## Search application details

Application number: 2019/62/91617/W	
What is the application for?:	Demolition of existing builders store/depot and erection of 5 dwellings, formati
Address of the site or building:	Store adj, 5, Fernside Avenue, Almondbury, Huddersfield, HD5 8NR
Postcode:	HD4 6EN

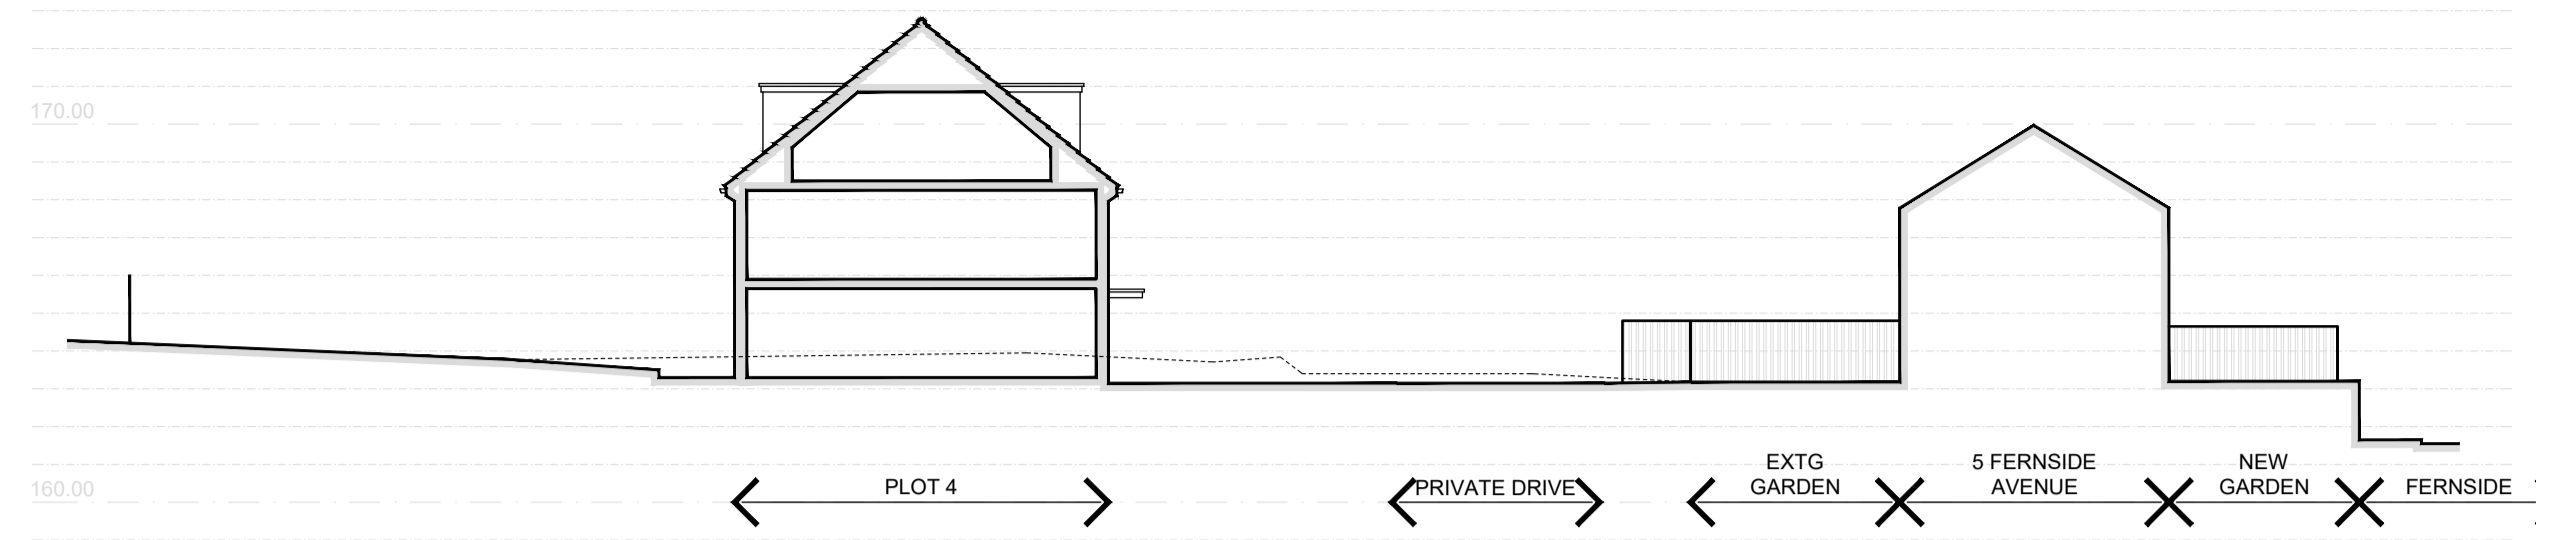
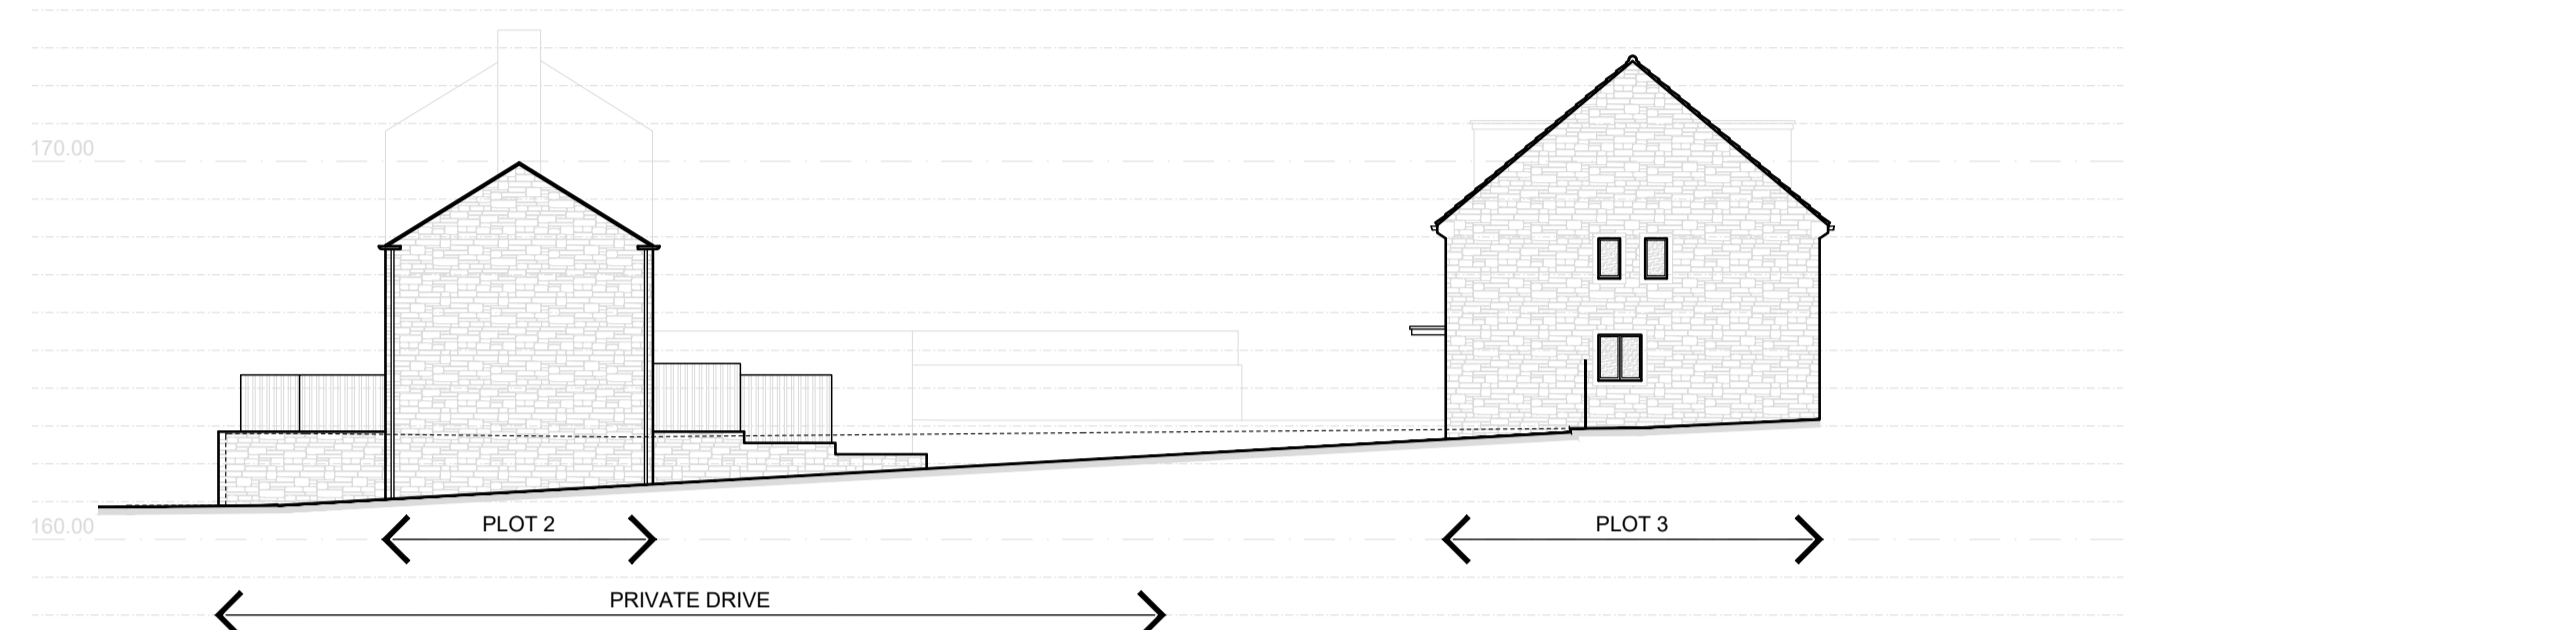
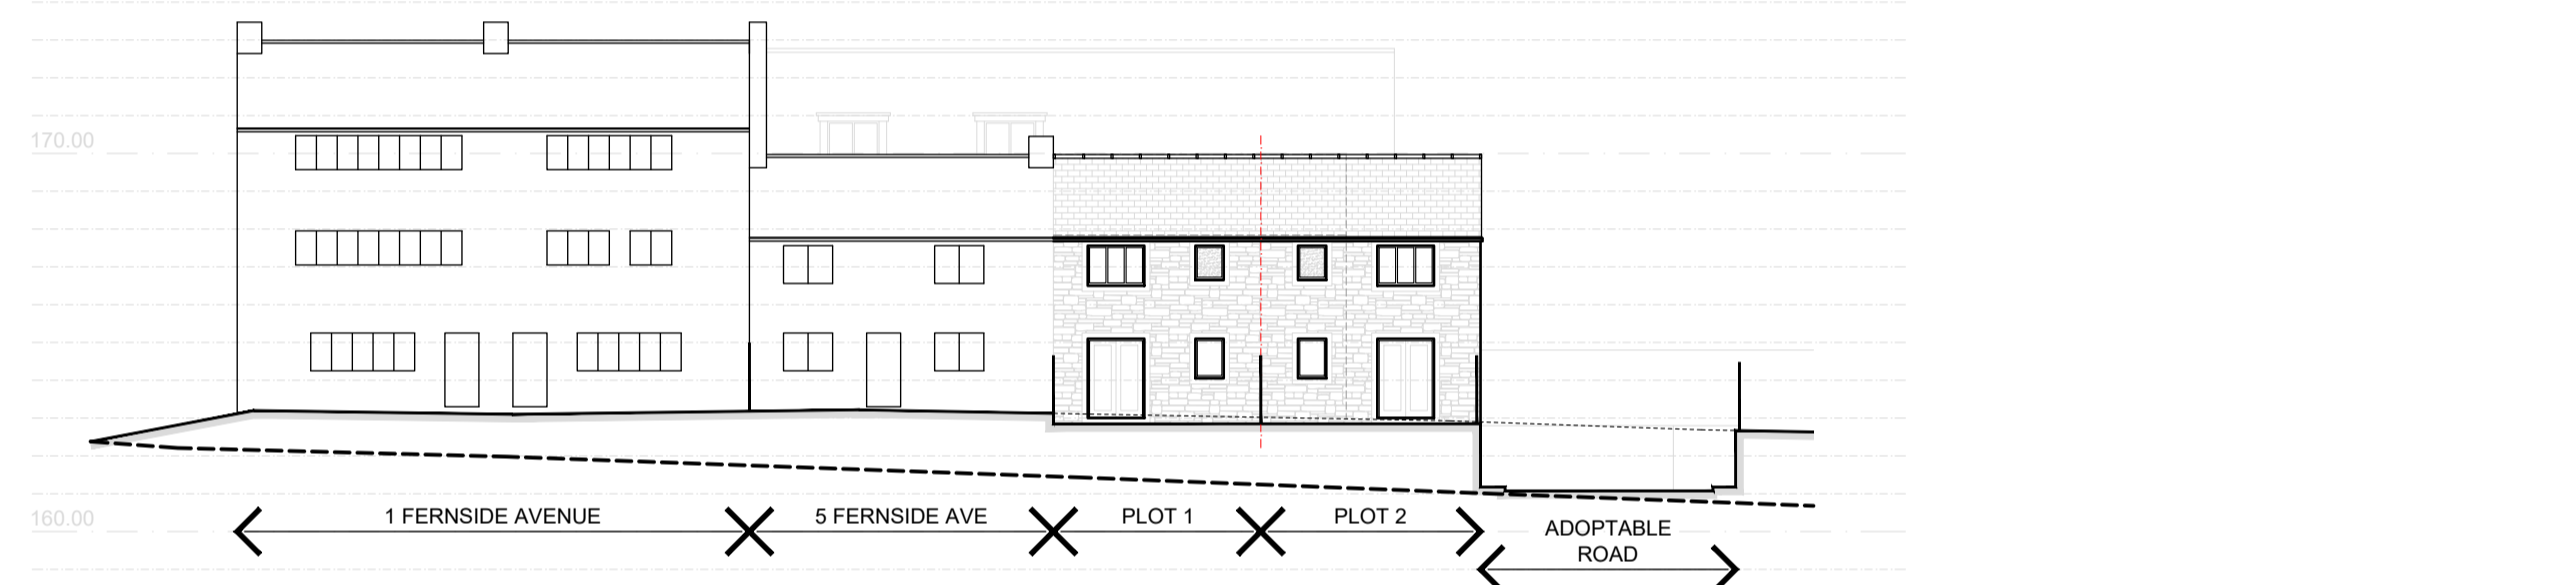
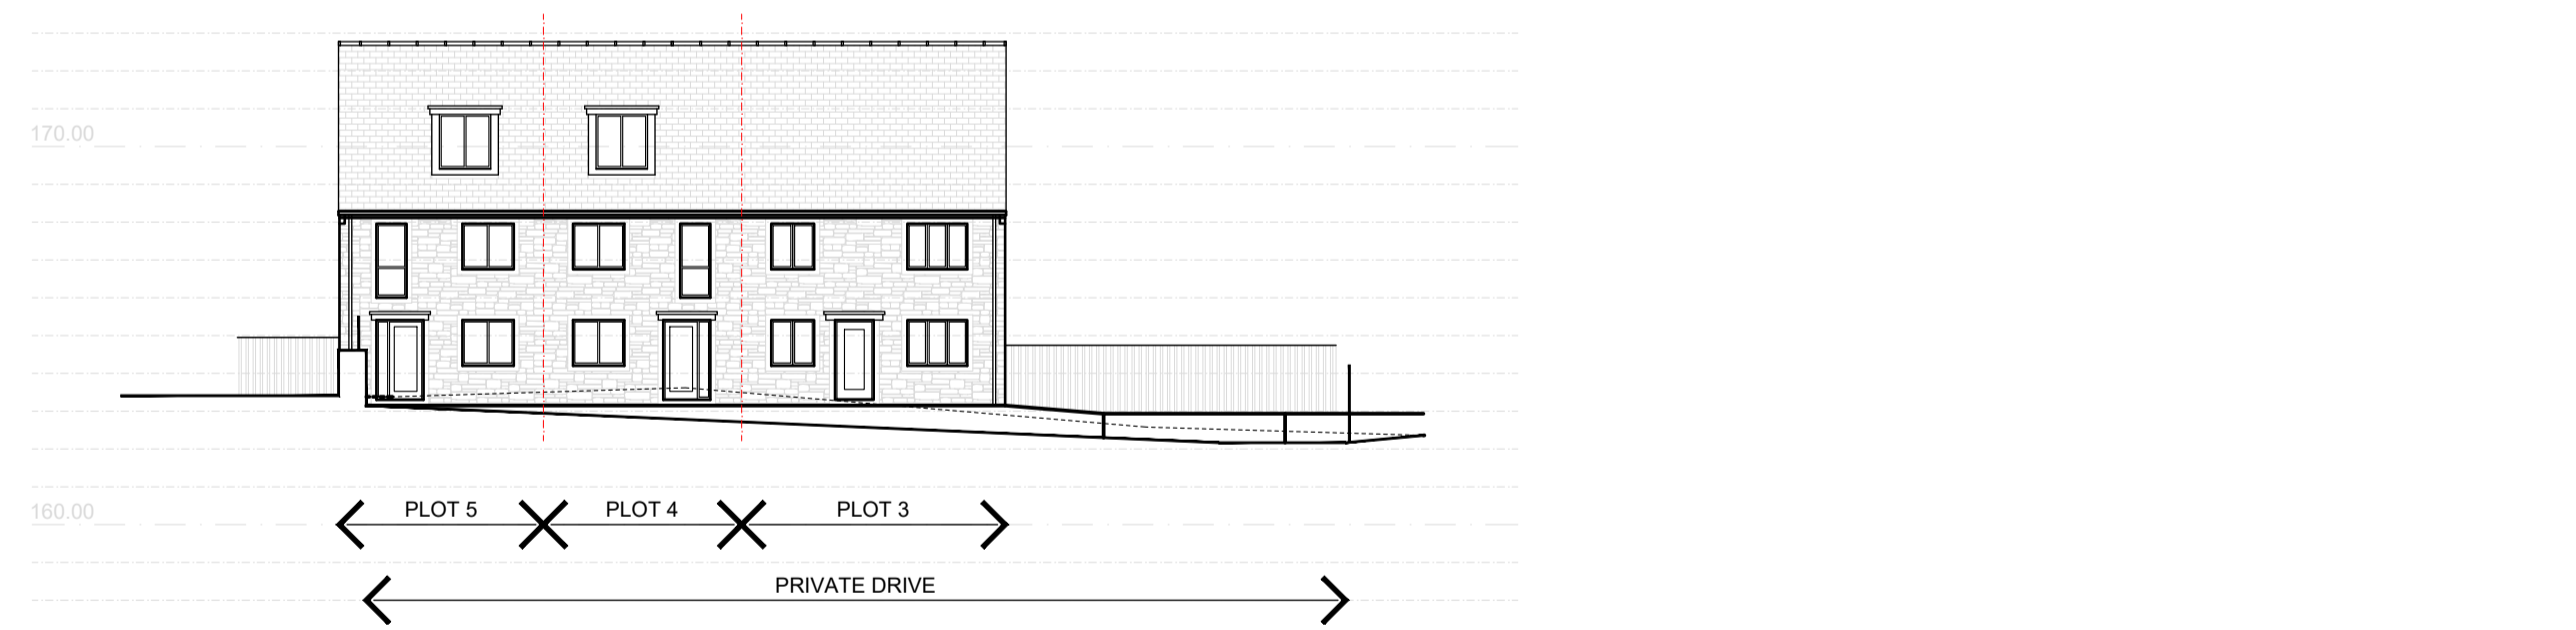
Type of comment: An objection
<p>Our objection is:</p> <p>Originally, the access in-front of _____ was only for foot access for Nos 3 &amp; 5 to the front and rear of their properties and vehicle access for the council depot (of vehicles under 3.5 tonne). To add, No3 is omitted from all the plans despite its existence, please note North Light site block plan, section C-C shows as all No1. No1 is on the left and No 3 on the right. You should also note that No 3 has access rights to the rear of their property and their rear-garden area (not shown on plans). The rear door to No 3 is part of an under-dwelling to No5. Both Nos5 &amp; 3 have a rear yard area including access to the rear of their properties. We can see from proposed plans that plot 2 front blocks all foot access to the rear of Nos 3 &amp; 5 and plot 1. Logistically this makes no sense as maintenance and upkeep of the lawns at the fronts of the block would involve occupants having to take lawn mowers, etc either through their properties or, around the new proposed cul-de-sac, onto Fernside Avenue (public highway) then back along the front along a proposed footpath. This makes no sense. It would be more logical for a footpath to run along the front of plot 2, directly from there onto the new road/footpath allowing occupants to have more direct access into the rear of the properties.</p> <p>We note from the plans (proposed site section B-B there is elevation from the front to the rear of plot 2. This requires an elevated footpath from the front of plot 2 to meet the new road/foot path to meet the elevated foot path on the proposed cul-de-sack road, once again allowing properties-Nos 3, 5 and Plot 1 &amp;2 a safe direct route to both fronts and rears of properties. This would make better sense than expecting everyone to make a detour onto a public highway</p> <p>By grassing the fronts, we agree that this would enhance the look of the area. As No3 has no vehicle access rights. Foot access rights would be maintained but from the cul-de-sac and not the busy main junction. This would result in only our vehicles exiting on a very dangerous junction thus improving highway safety. We would then also like to grass the front of our property thus making it a sole entry drive. This would also further enhance the front as we could match the grassed areas.</p> <p>Additionally, we have objections to plot 4 and 5 top floor windows looking over into _____ thus compromising our privacy.</p>
